Application Number: 2019/62/93797/E

10 May 2021

Planning conditions:-

(HB Project responses in red)

P21-3278-00-01

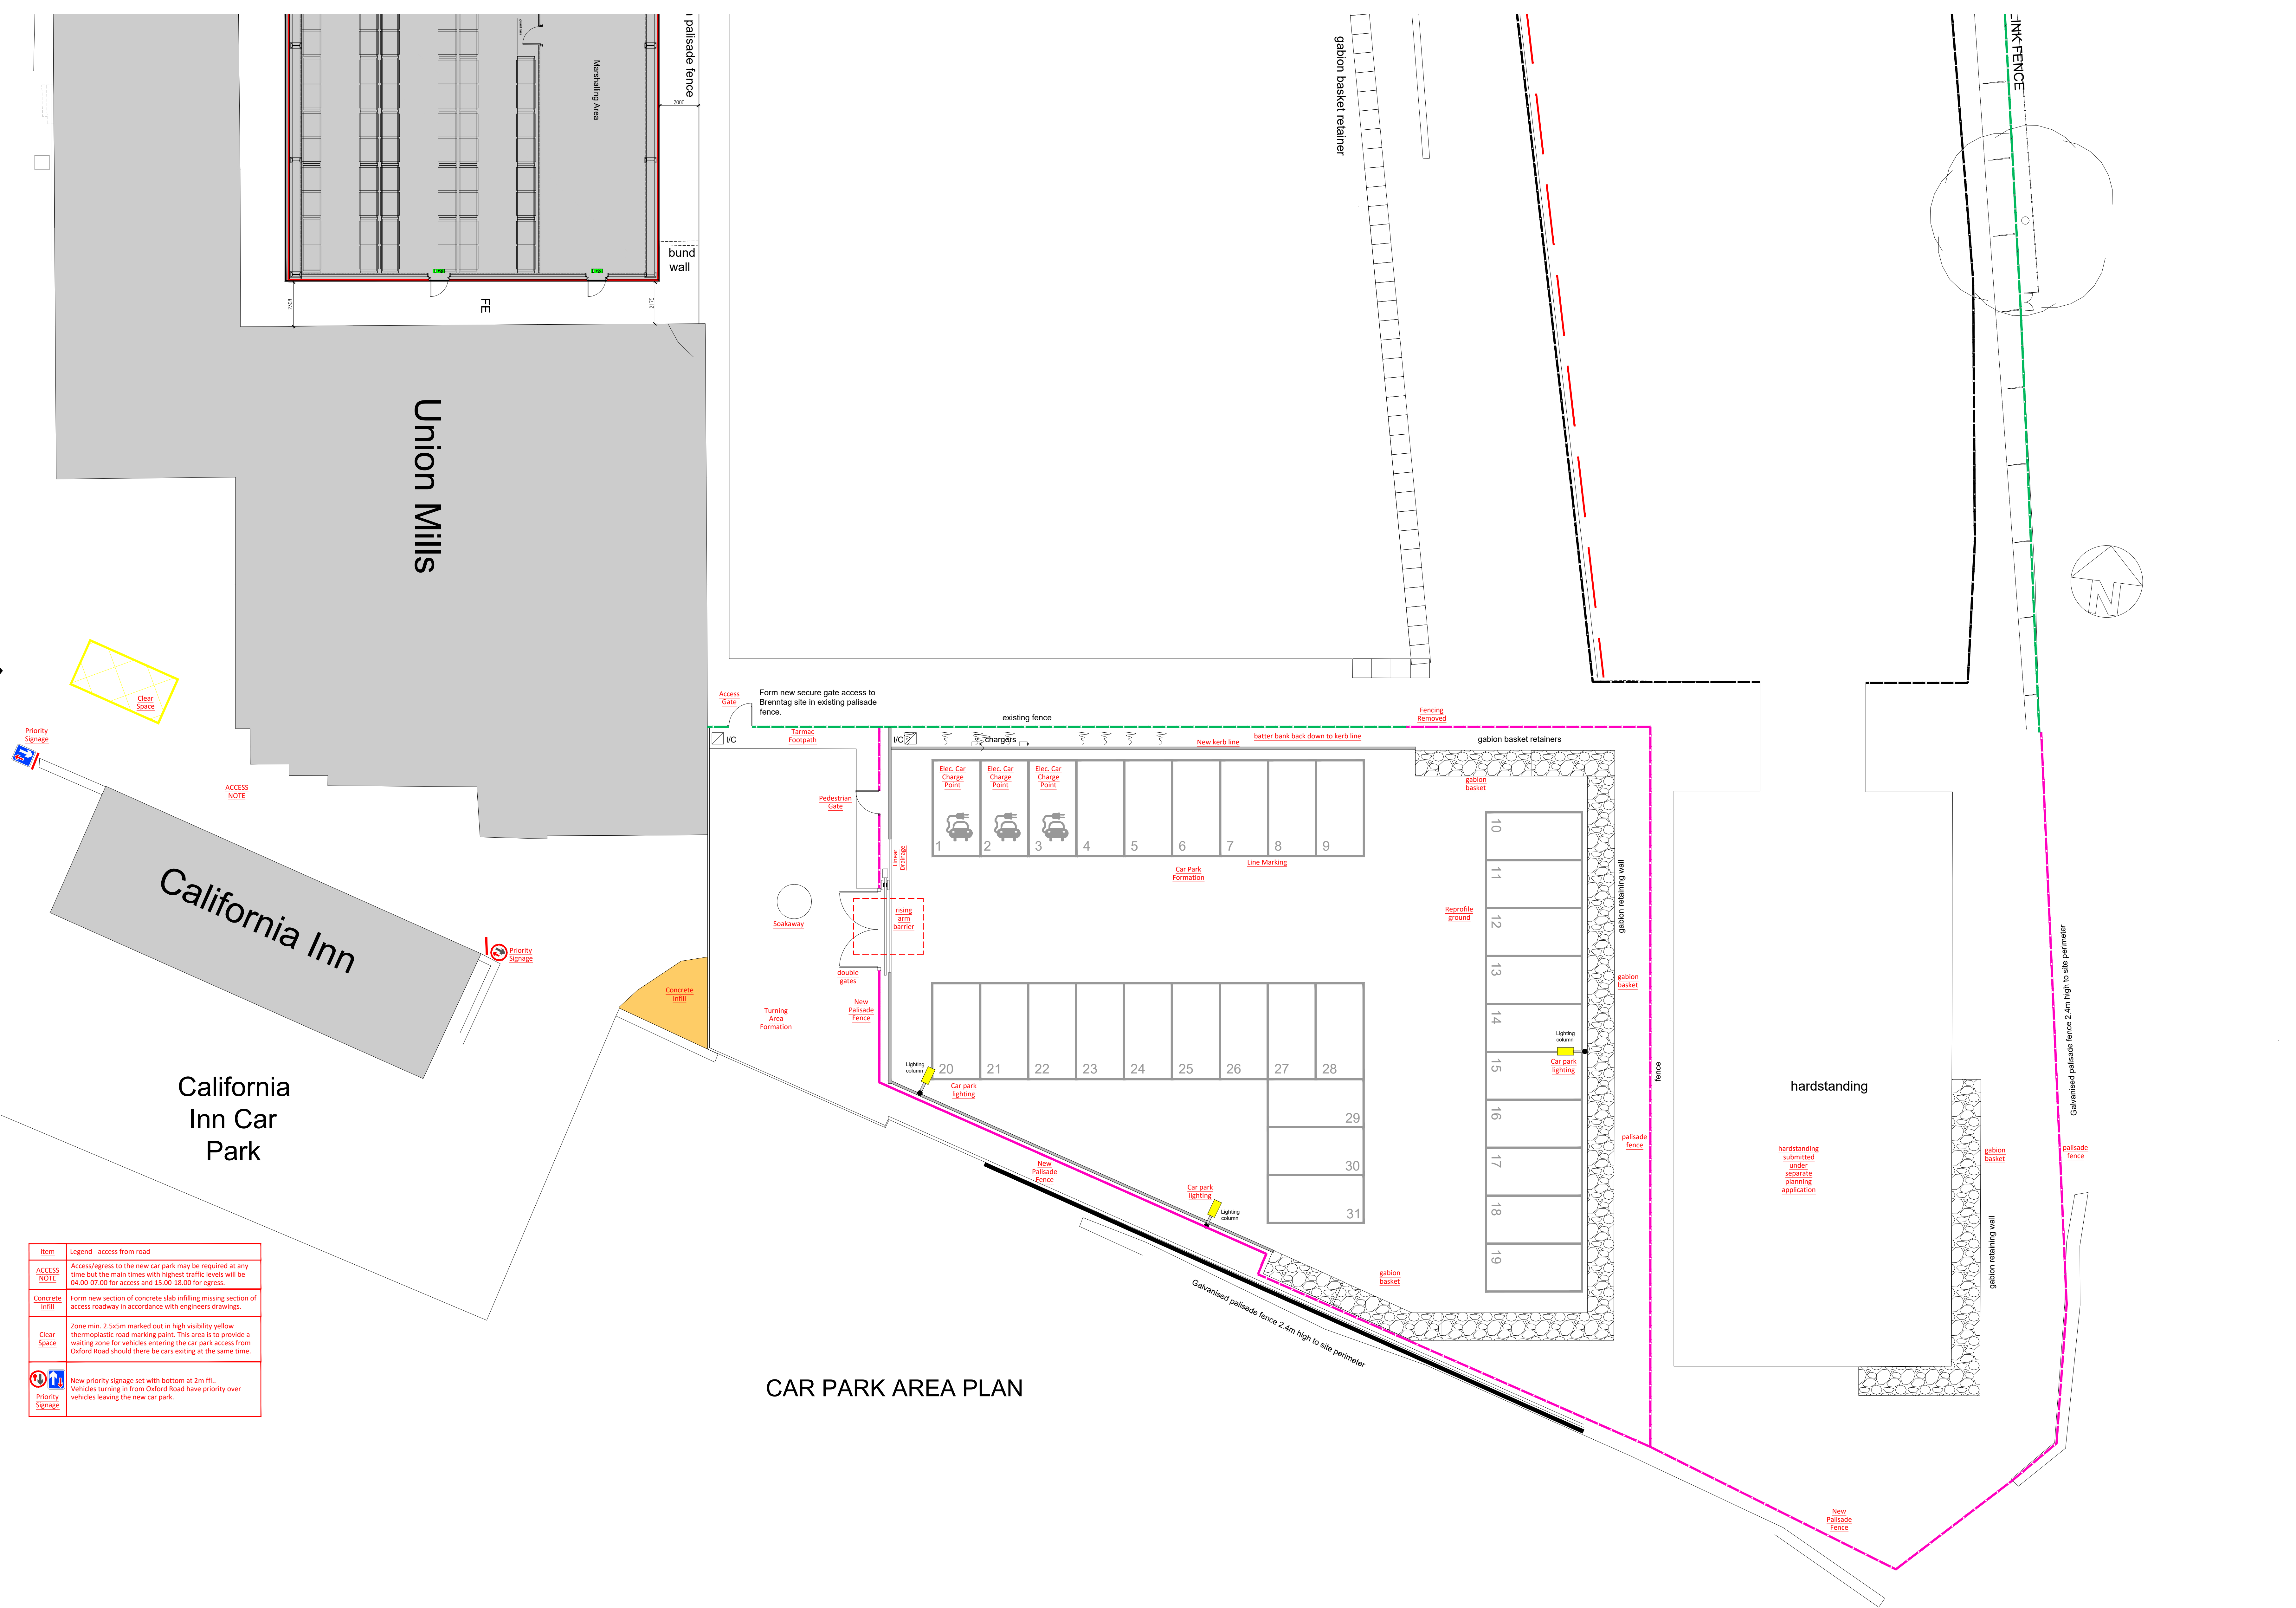
8. Before development of the car parking area hereby permitted commences a scheme detailing the dedicated facilities that will be provided for charging electric vehicles and other ultra-low emission vehicles shall be submitted to and approved in writing by the Local Planning Authority. The scheme shall meet at least the following minimum standard for numbers and power output:-

- One Standard Electric Vehicle Charging Point for every 10 unallocated commercial parking spaces

Buildings and parking spaces that are to be provided with charging points shall not be brought into use until the charging points are installed and operational. Charging points installed shall be retained thereafter.

Electric charging bays have been supplied and drawing P21-3278-00-01J uploaded on planning portal.
